**MEMORANDUM**

FROM: Kim Bryant, Water Operations Supervisor  
Tim King, Utility Construction Lead II  
Ryan Keefe, Water Operations Lead II

SUBJECT: Hsiao Short Plat 3<sup>rd</sup> Submittal, SP22004

SEWER & WATER PLAN

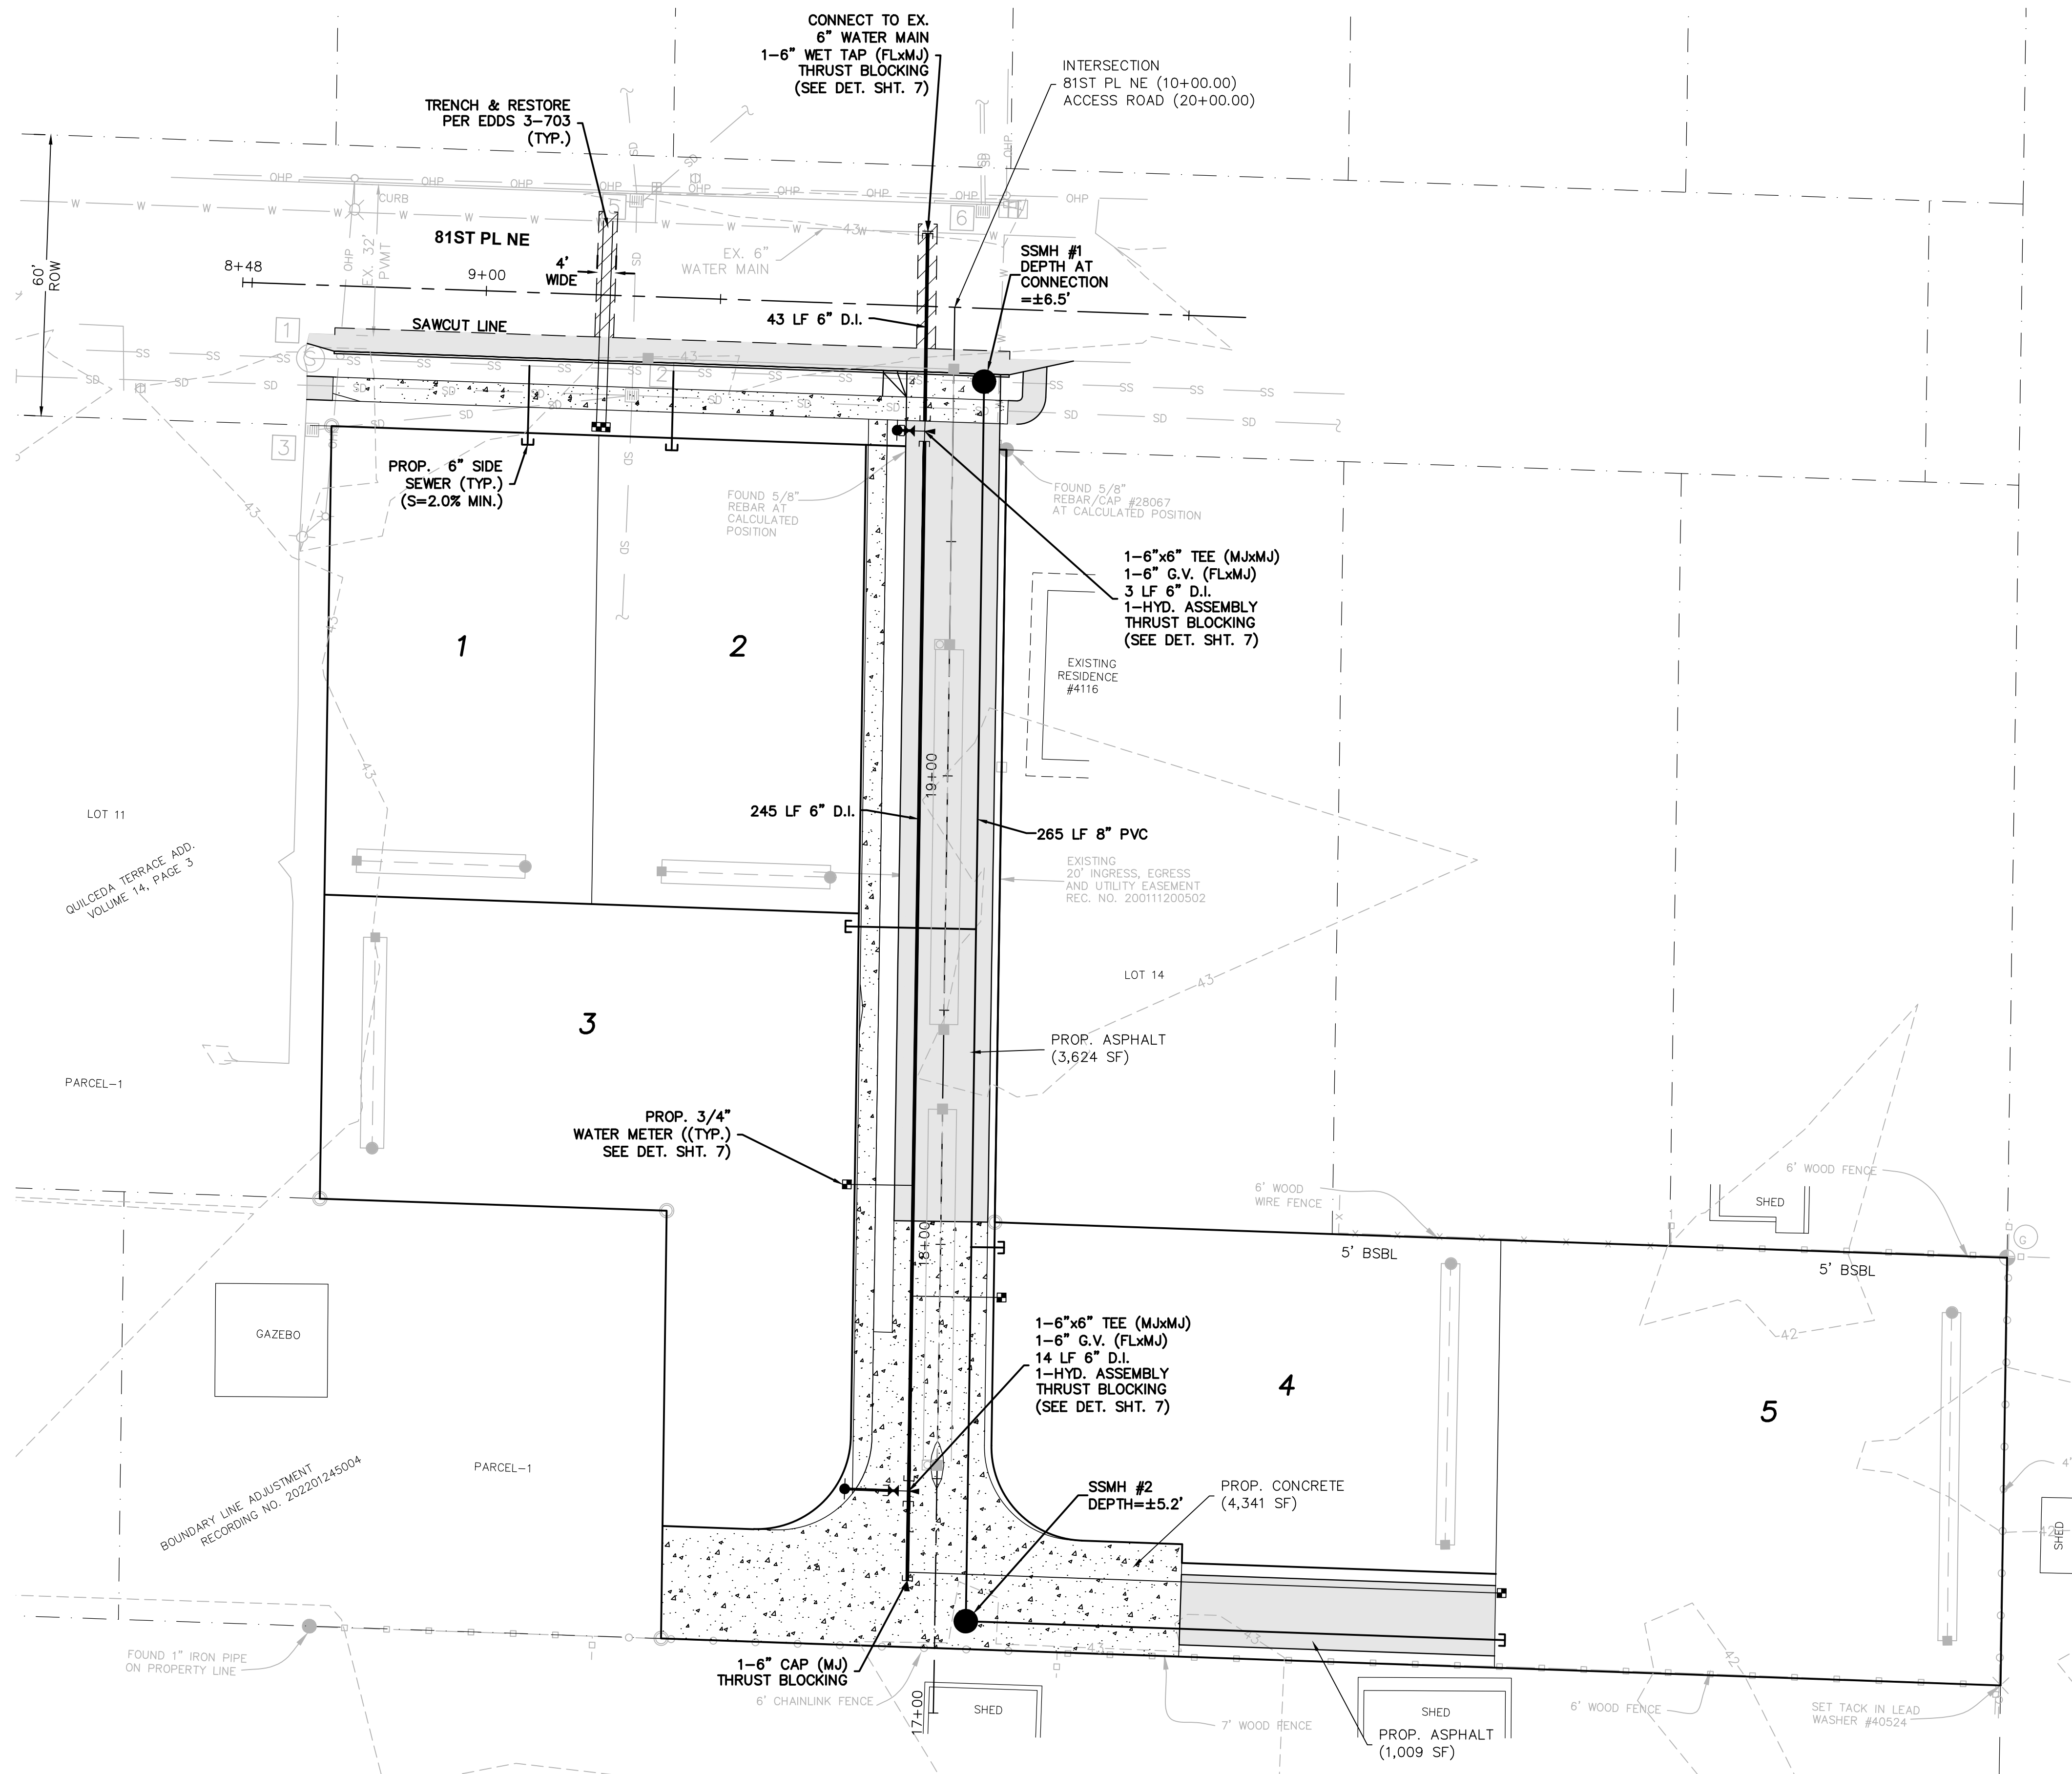
1. 6" cap is called out at end of water main, needs to be changed to an 8" cap with blow off;
2. If water service for Lot 5 could be moved north to out of driveway that would be preferred.
